DECISION DELEGATED TO HEAD OF PLANNING

Application No: H16-0349-22 **Applicant:** C K Hutchison Networks (UK) Ltd

Proposal: Proposed 15.0m Phase 9 super slimline monopole & associated ancillary works

Location: Wygate Park Spalding

Title: 260 PROPOSED ELEVATION

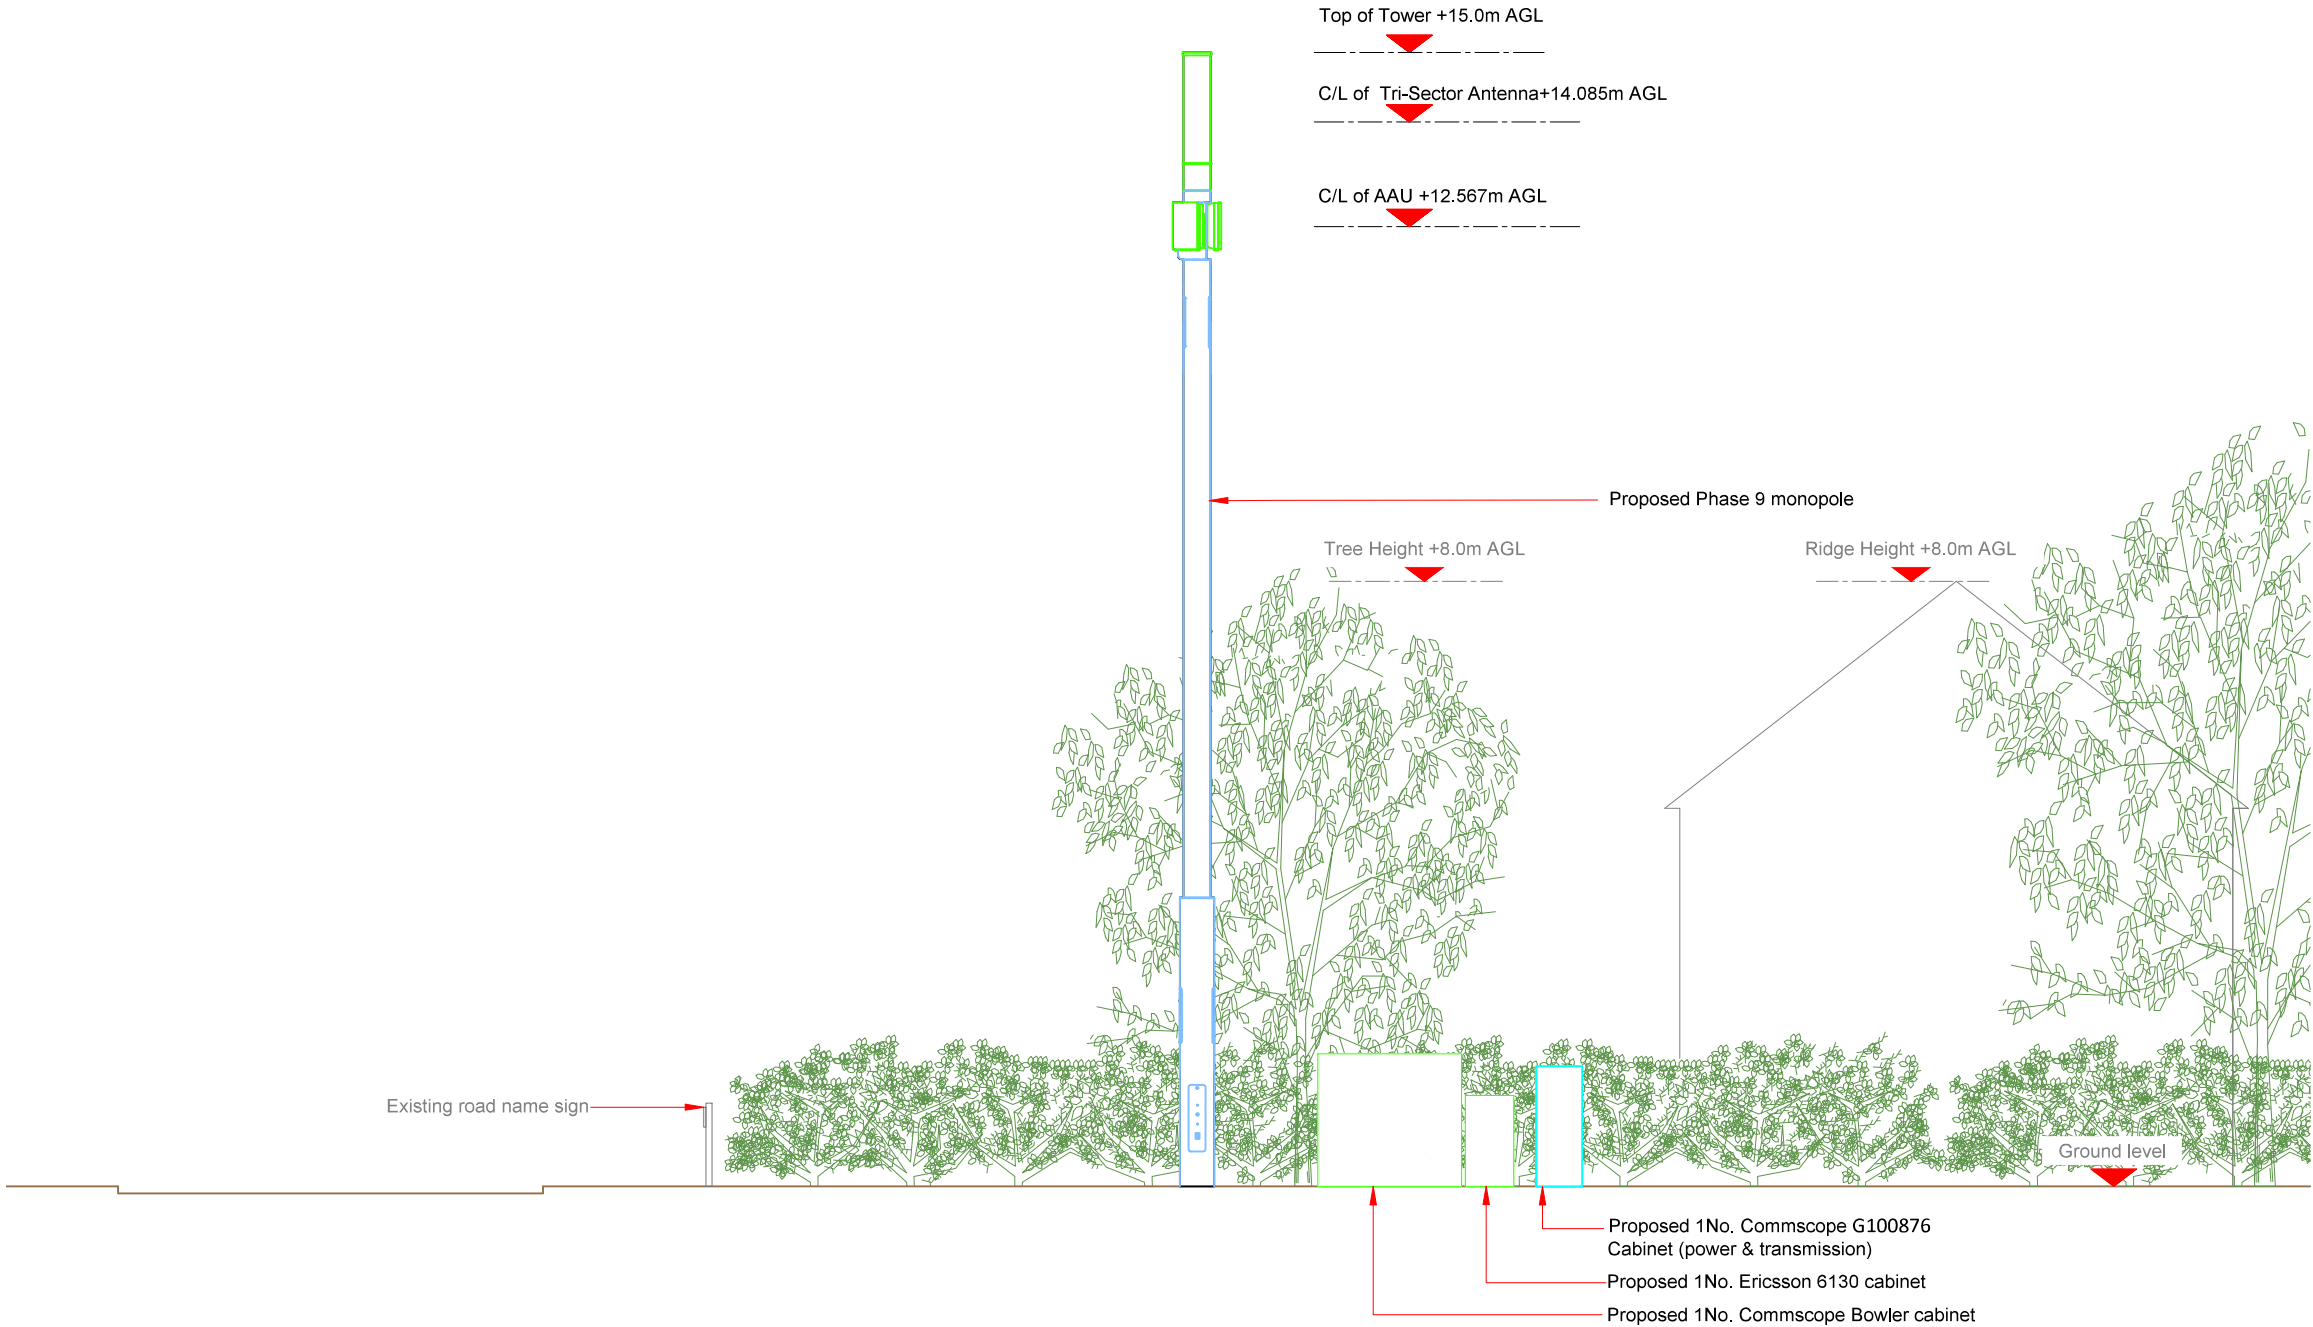
Since the previous application was refused, the proposal has been revised from a 15.0m Phase 8 monopole with wraparound cabinet at base, to a 15.0m Phase 9 super slimline monopole with no wraparound cabinet at base. The monopole is approximately 500mm narrower at its widest point

compared to that previously proposed, now being a maximum of around 500mm in width. Notwithstanding this alteration and the loss of the wraparound cabinet, the monopole would still be readily visible in the street scene and the scale is not directly not comparable to any other structure or building in the vicinity. It would be visible at a distance on Wygate Park from a westerly direction and would be well above the tree line and roof line of properties in the vicinity. The mast would be sited almost immediately adjacent to a well-used footway and would therefore be visually obtrusive to pedestrians, as well as motorists. Whilst it is accepted that there is other street furniture in the vicinity (such as street lights, road signs and post boxes), it is considered that the proposal, even reduced in height, would have a material adverse impact on the wider street scene due to it being an unduly dominant, obtrusive and alien feature within the street scene.

In light of the above, the proposal is considered to be unacceptable in terms of its siting and appearance and therefore contrary to Policies 2 and 3 of the South East Lincolnshire Local Plan (2019). Policy 2 of the Local Plan requires development proposals to take into account sustainable development considerations such as: size, scale, layout, impact on trees, character and appearance of the area and the relationship to existing development. Policy 3 requires development proposals to respect the scale and massing of neighbouring buildings and the landscape character of the location.
